Site 8C Commercial Building

**Murray Rose Drive, Sydney Olympic Park,
Homebush NSW**

Review of access for people with a disability

Prepared by: Access Associates Sydney

Site 8C Commercial Building
Sydney Olympic Park
Basement 2 Plan

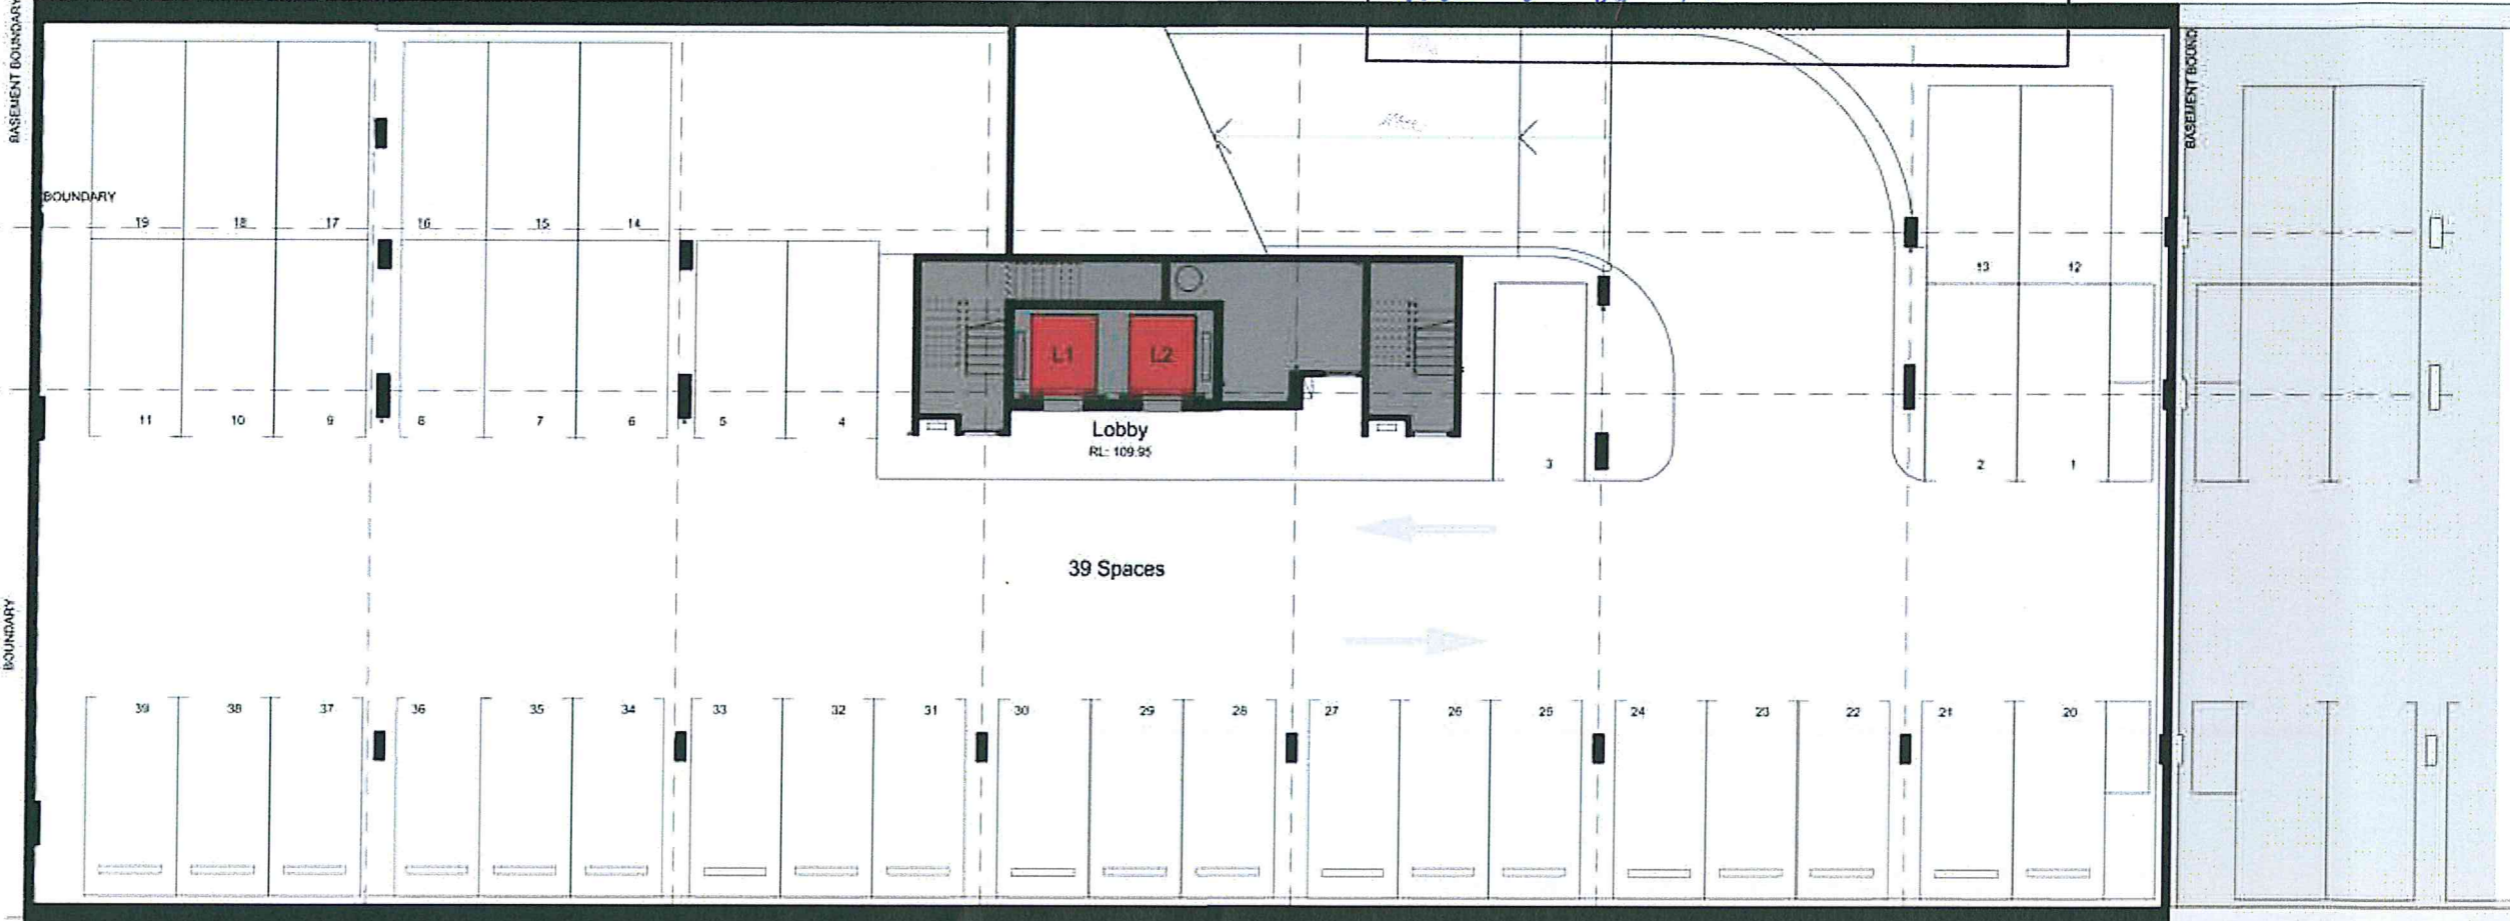
- (i) Ensure in ongoing design the accessible parking space includes dimensions and a layout to meet the requirements of AS2890.6 (2009) figure 2.3.

Scale: 1:100 @ A1 / 1:200 @ A3
 Drawn: JC
 Checked: BR
 Project No: S11610
 Status: EA Application
 Plot Date: 25/6/2013 4:58:12 PM
 Plot File: S:\11600-11609\A1\1810_bca_area_3c00_narratedplan.DWG
 Drawing No: [Revised]
A02.00[A]

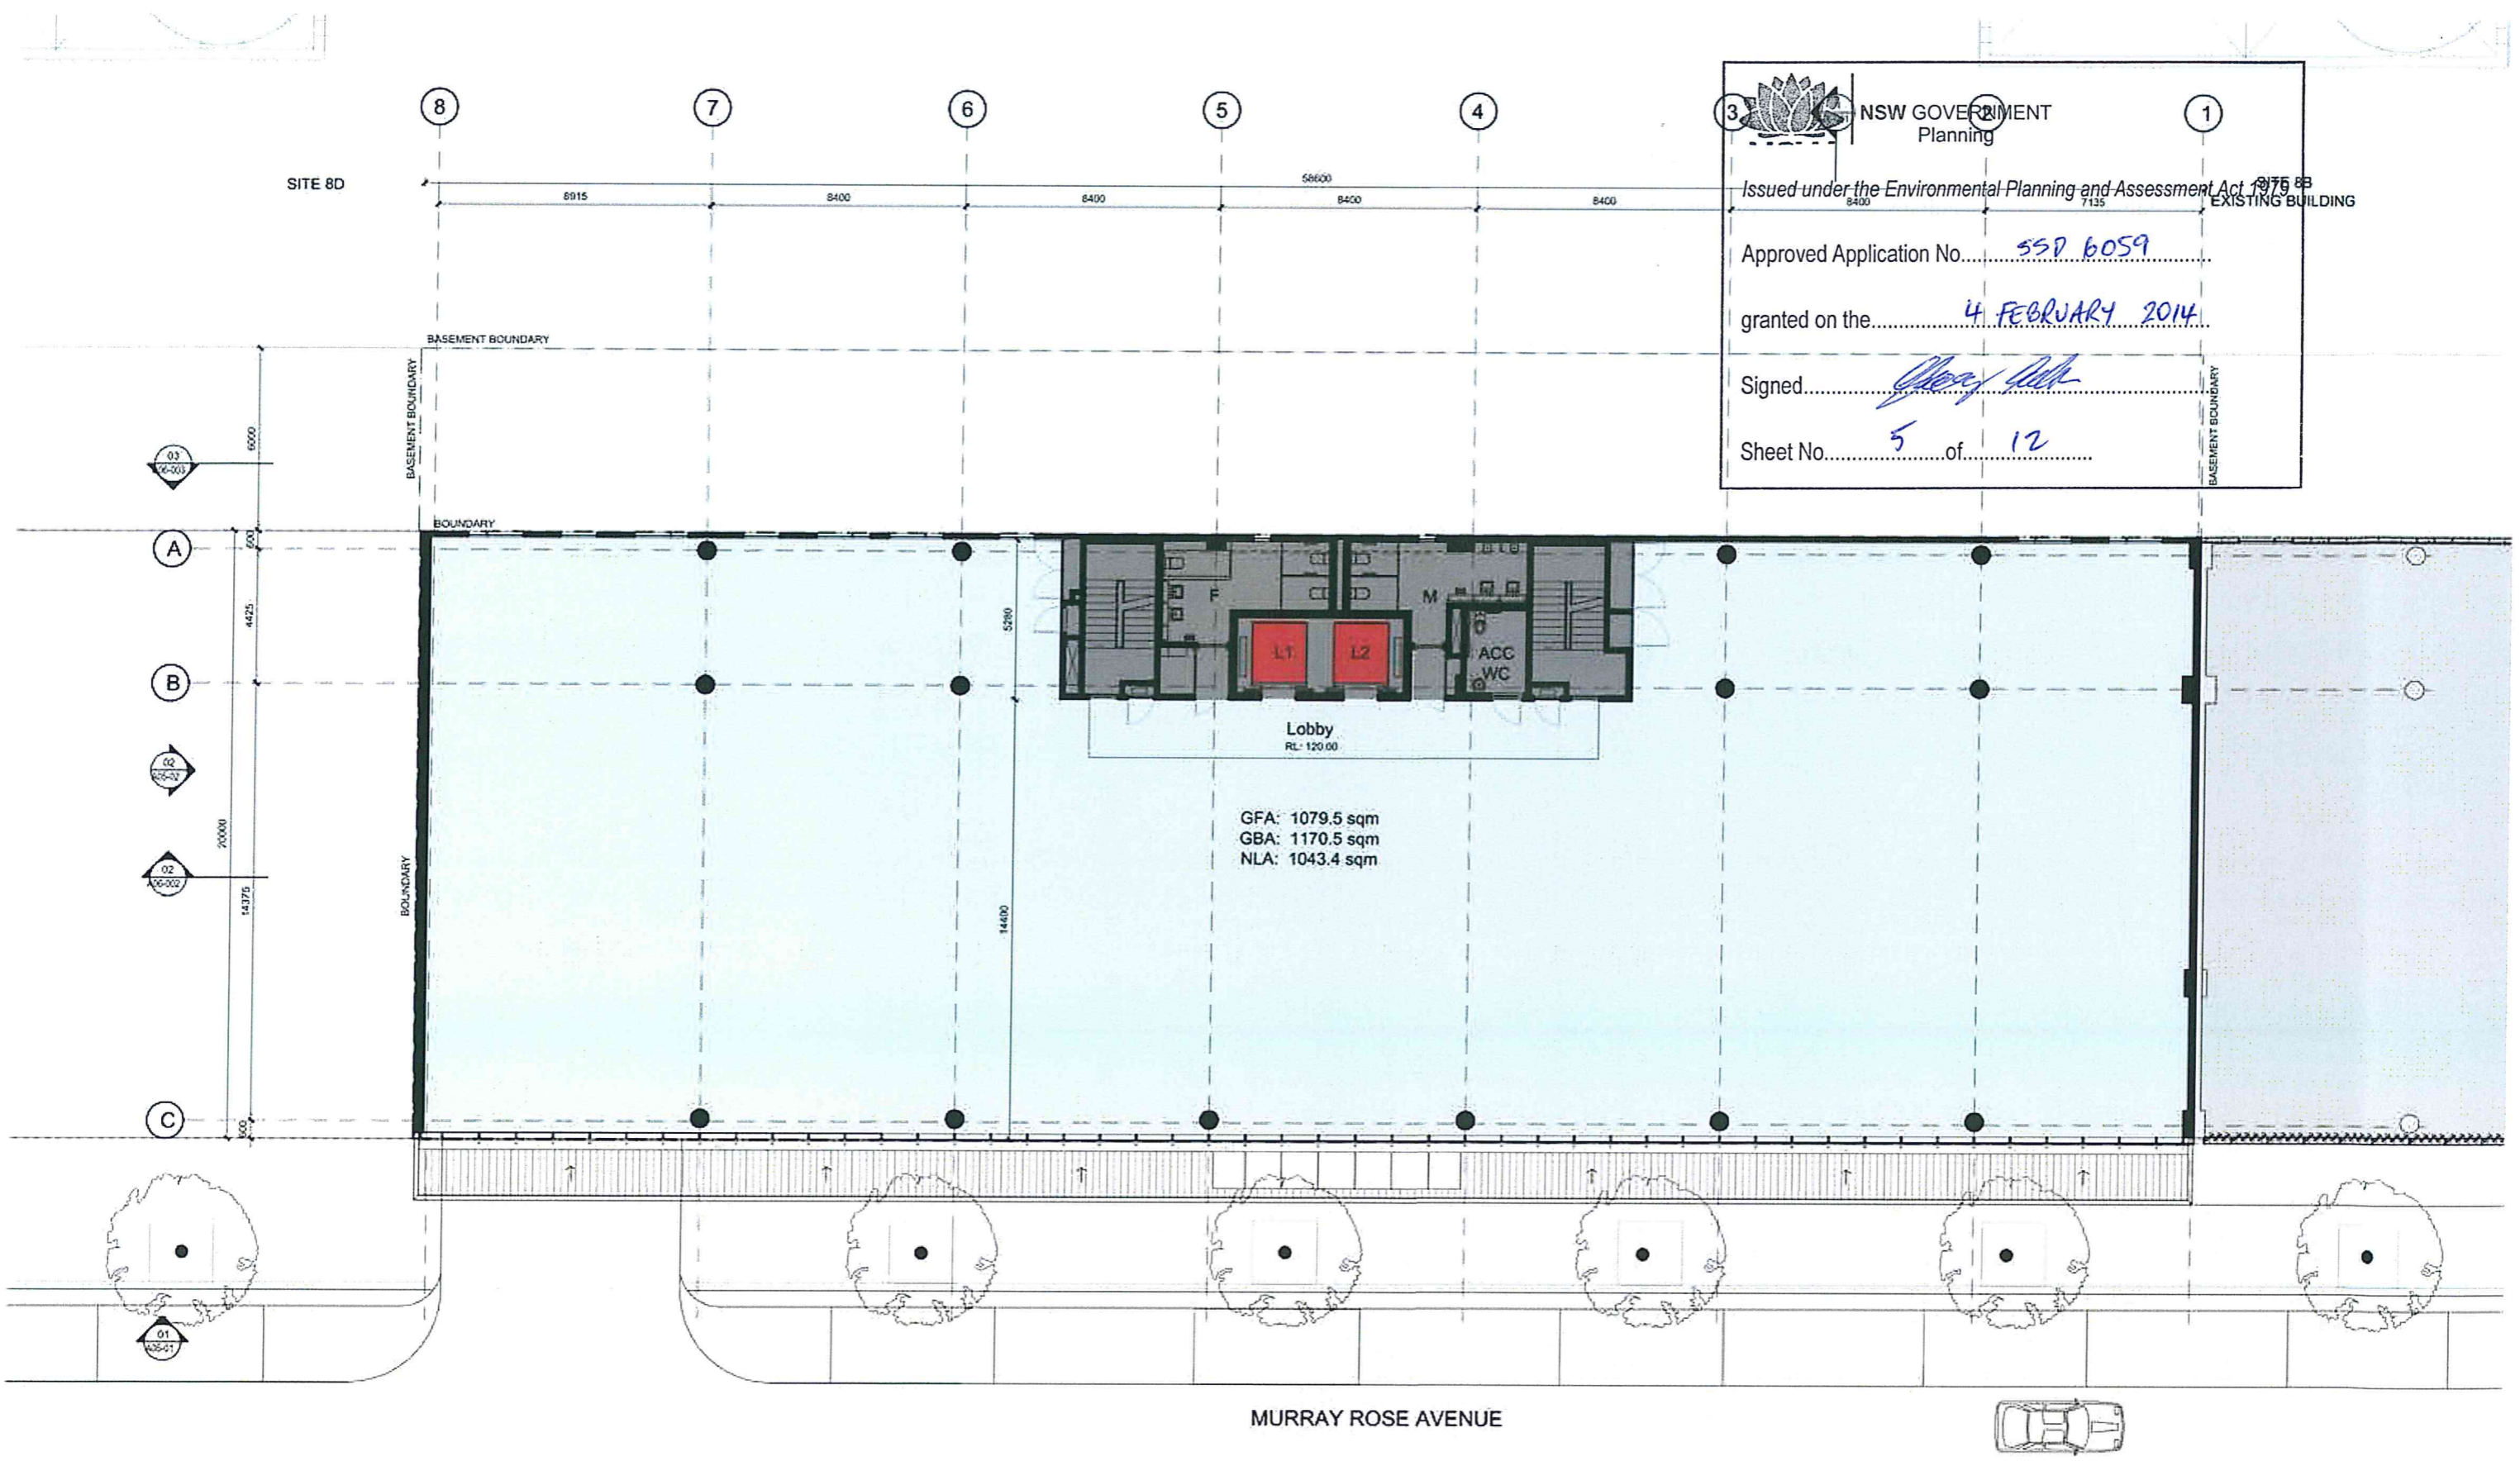
- (i) Ensure the retail entries from the access lane include accessible paths of travel that meet the requirement to meet the BCA (2013) clause D3.2 - Access to buildings which requires the principal pedestrian entrance to be accessible in all cases and not less than 50% of all pedestrian entrances, including the principal pedestrian entrance to be accessible. In buildings with a total floor area of more than 500 square meters, an inaccessible entrance cannot be more than 50 meters from an accessible entrance.

- (ii) Ensure in construction the entry pathways comply with AS1428.1 clause 6 and include slip resistant surfaces and lips at abutting surfaces of not more than 5mm.

- (iii) Ensure in ongoing design to meet the BCA part D3.12 (2013) that the unframed glazed doors and walls are provided with visual indicators to fully comply with AS1428.1 clause 6.6 (2009) and that doorways are provided with luminance contrast to meet the requirements of AS1428.1 clause 13.1 (2009).

- (iv) Ensure in ongoing design that retail doors, including a single leaf of double doors, include a minimum clear opening of 850mm to comply with AS1428.1 clause 13.2 (2009).

- (v) Ensure in ongoing design the external door linking the commercial lobby and letterboxes include circulation space to meet AS1428.1 figure 31 and the door and card reader.

- (vi) Ensure in going design the step ramp indicated on the northern side of the commercial lobby includes features, gradient, landings, surface finishes to meet AS1428.1 clause 10.

Site 8C Commercial Building
Sydney Olympic Park
 First Floor Plan

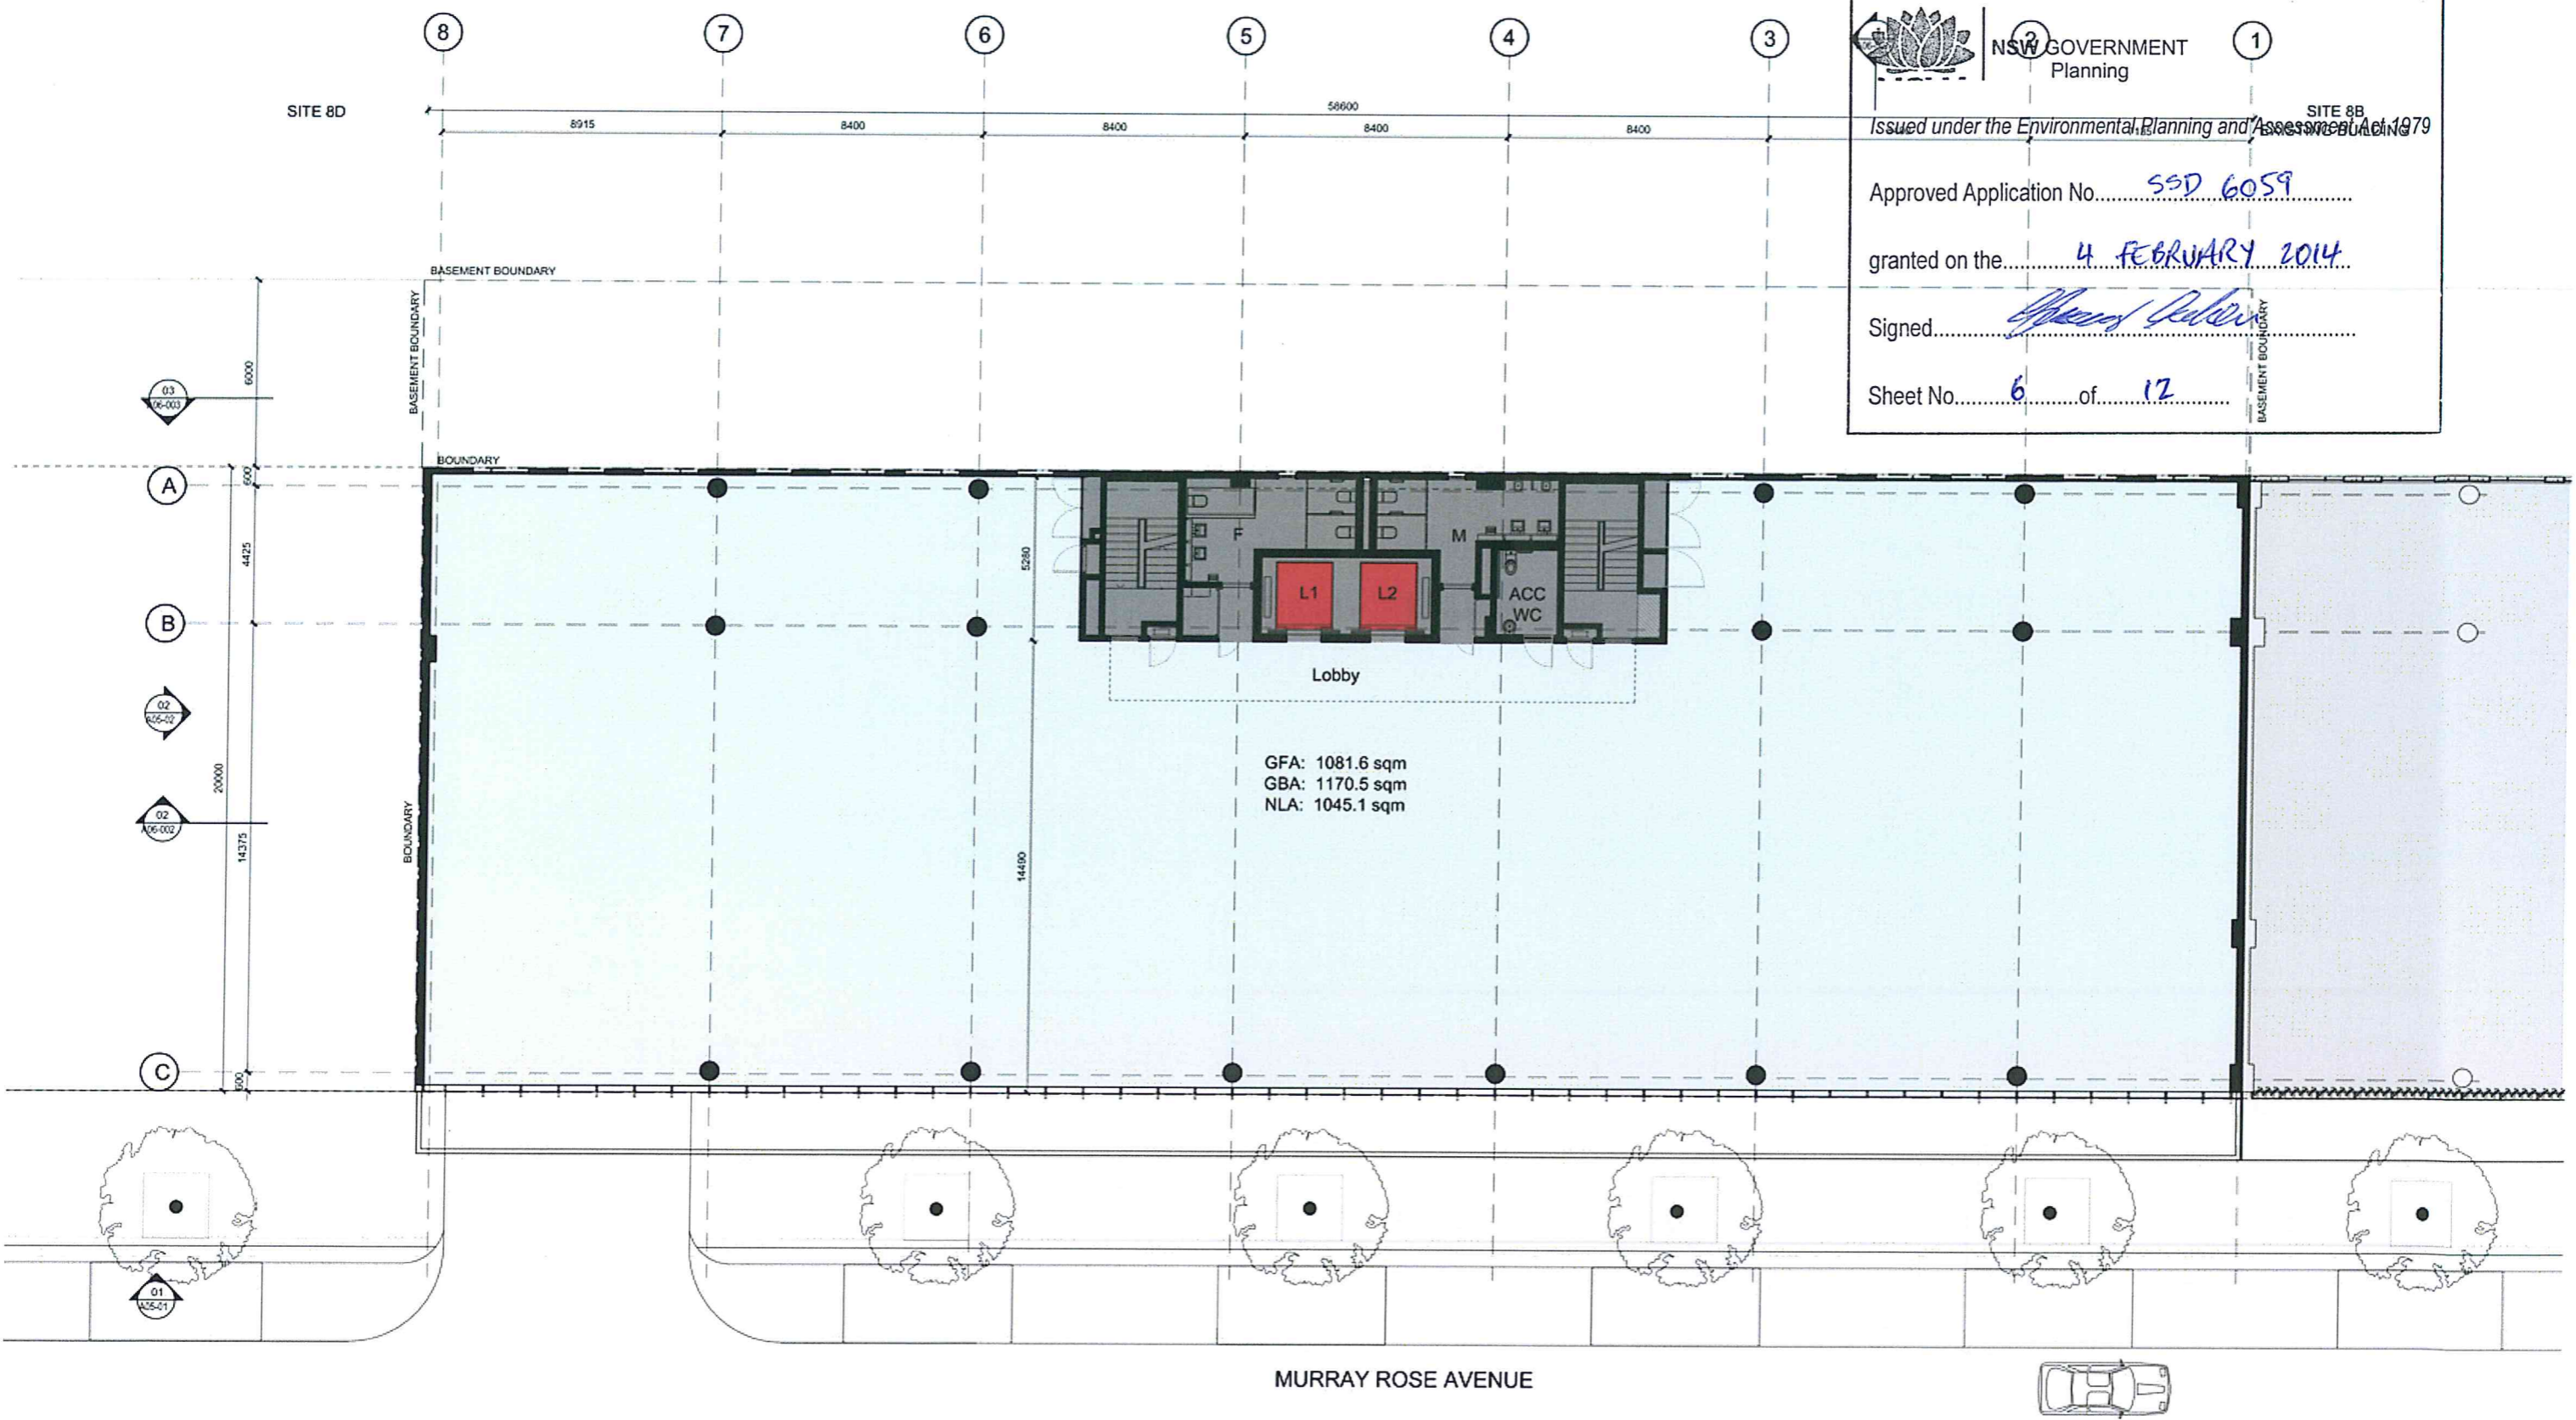
- (i) Ensure in ongoing design the lift lobby includes slip resistant floor finishes and uses colour contrast at the fixed seat/wall and floor to prevent the creation of hazards for people with low vision.

- (i) Ensure that in ongoing design unisex accessible sanitary facilities include a layout, circulation space (door, WC pan, basin) and fittings to meet the requirements of AS1428.1 clause 15 and that both right hand and left hand layouts are provided.
- (ii) Ensure in ongoing design that cubicles for people with ambulant disabilities include features complying with AS1428.1 clauses 13.4 and 16 and figures 34 and 53 (signage, entry airlock and cubicle door circulation, WC pan, grabrails, toilet paper dispenser, clothes hook).
- (iii) Ensure in ongoing design the locker includes door controls located within an accessible reach range that meets the requirements of AS1428.2.
